Variation of condition 2 imposed under AW/139/19/HH relating to approved plans for balcony to first floor over approved flat roof. This application may affect the character & appearance of the Craigweil House Conservation Area.

19 Kingsway Aldwick

Thank you for your internet representation made on 14th November 2019 which has been recorded as '**an objection**' with the comments as follows:

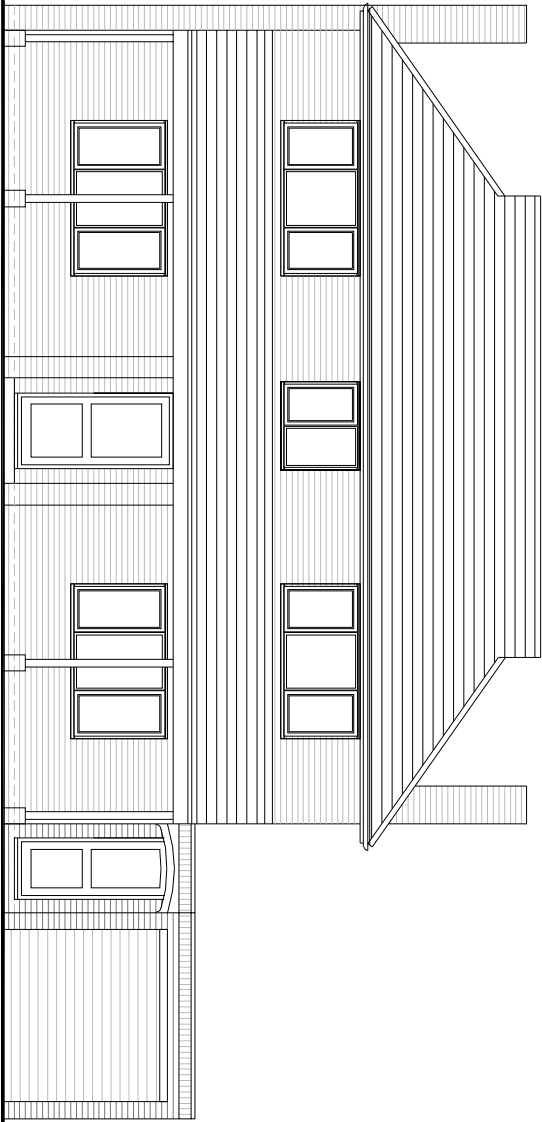
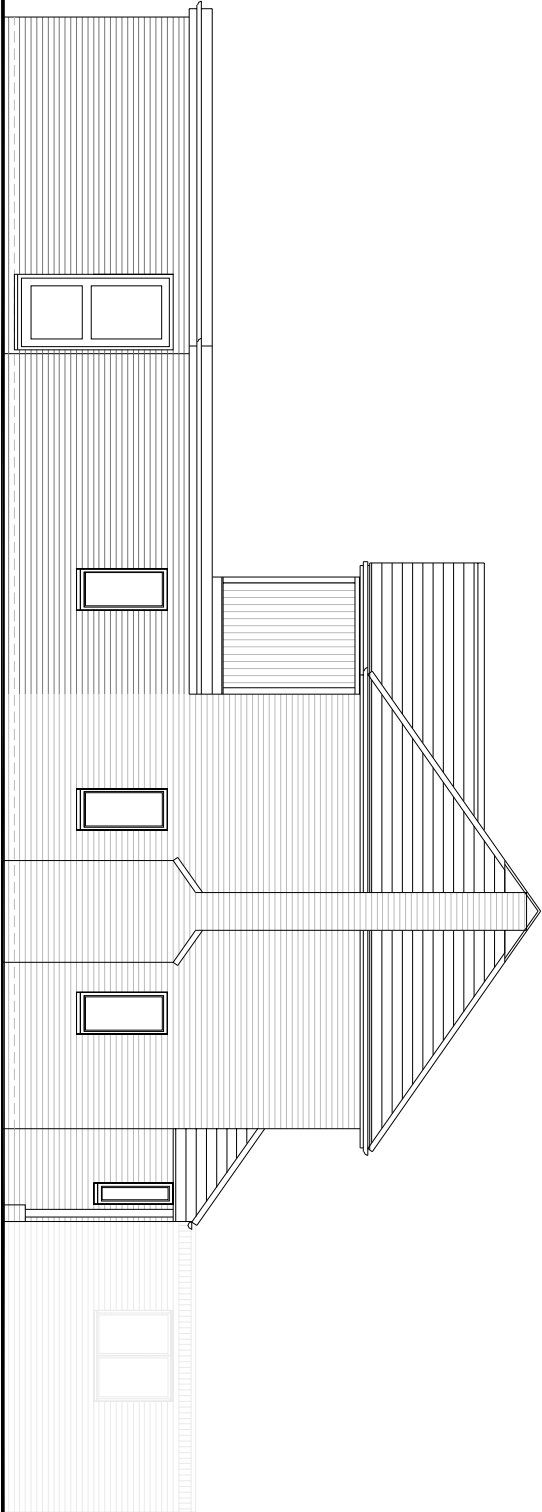
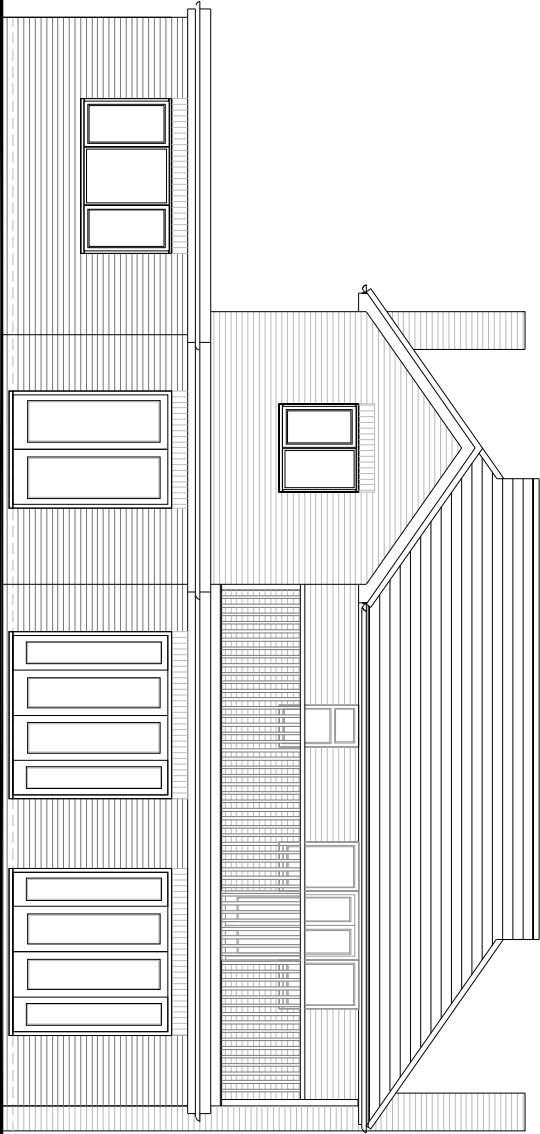
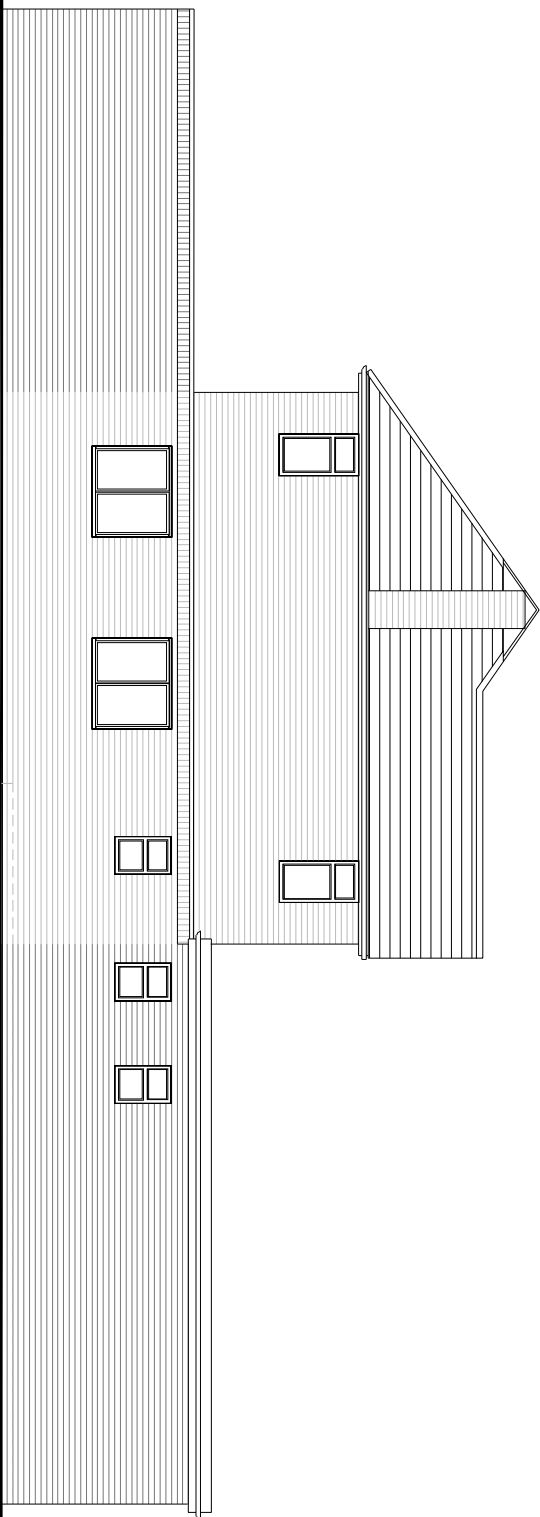
We believe to have a balcony and sit in an elevated position overlooking the majority of our garden is a considerable invasion of our privacy. We would welcome a visit from the planning officer to have an appreciation of this and understand our concerns. This is an additional 'add on' to the original planning application and should it have been on the original application we would have objected previously.
